A57 LINK ROADS

TR010034

CPRE Peak District and South Yorkshire Branch

CPRE PDSY DEADLINE 4 SUBMISSION – RESPONSE TO ISSUE SPECIFIC HEARING 2

**A57 Link Roads
TR010034**

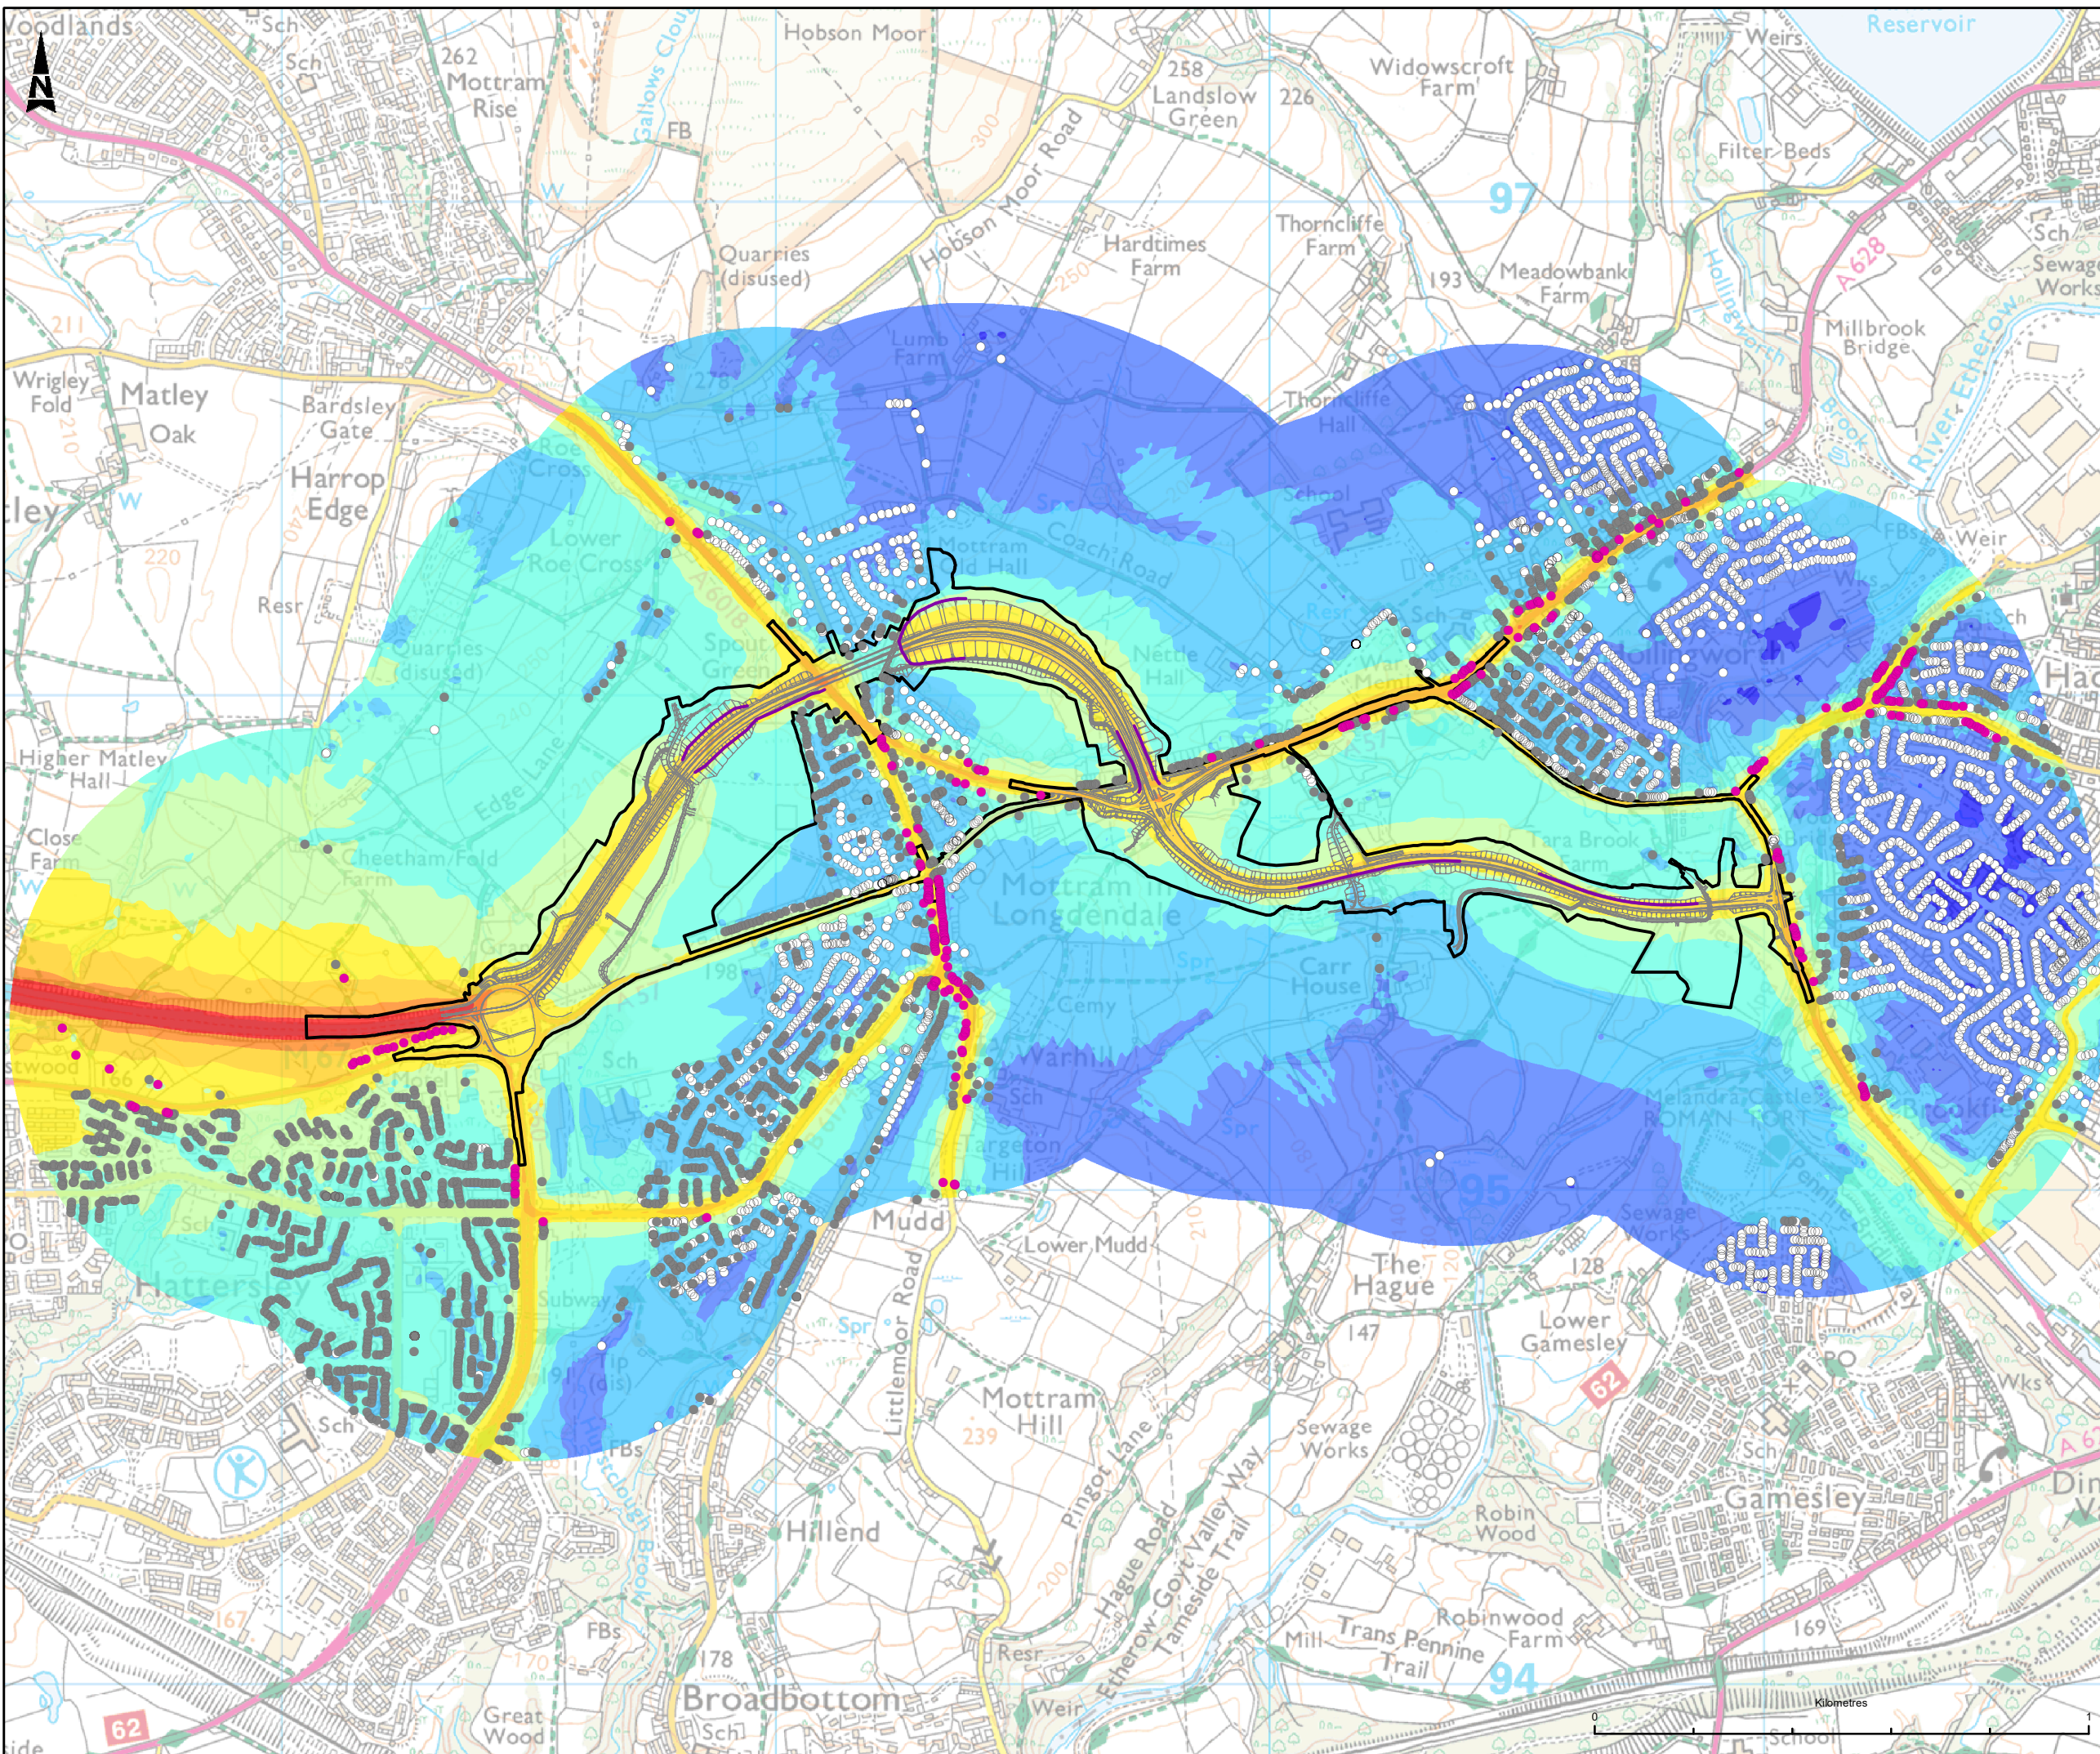
Using the single element noise to measure the impacts of the scheme on National Park's landscapes fails to capture the full effects of the increased traffic. Noise is only one element of tranquillity, which is a multi-layered quality of the countryside and part of the natural beauty of the National Park. Tranquillity is the calm experienced in places with mainly natural features and activities. CPRE's maps reflect both physical qualities and elements and the subjective experience of tranquillity – what is tranquillity, what detracts from it and what enhances it. As the tranquillity map of Derbyshire (page 14) shows the landscape around the A57 Snake Pass is one of the most tranquil in the Peak District. It is a natural landscape, wide open blanket bog and heather moorland, with birds such as curlew and golden plover but above all where silence peace and quiet can be found. The landscape around the A628 is less tranquil but the aesthetic and perceptual qualities are strong in the landscapes adjacent to both roads - solitude, inspiration and awe at the astonishing beauty, threat from the terrain or weather. The top detractor from tranquillity according to the

CPRE assessment is hearing constant noise from cars, lorries and motorbikes. Traffic was strongly verified as being something not seen in a tranquil place, and car noise as something

not heard in a tranquil place. If National Park purposes are to be met and tranquillity enhanced then traffic along both routes should be reduced, not increased.
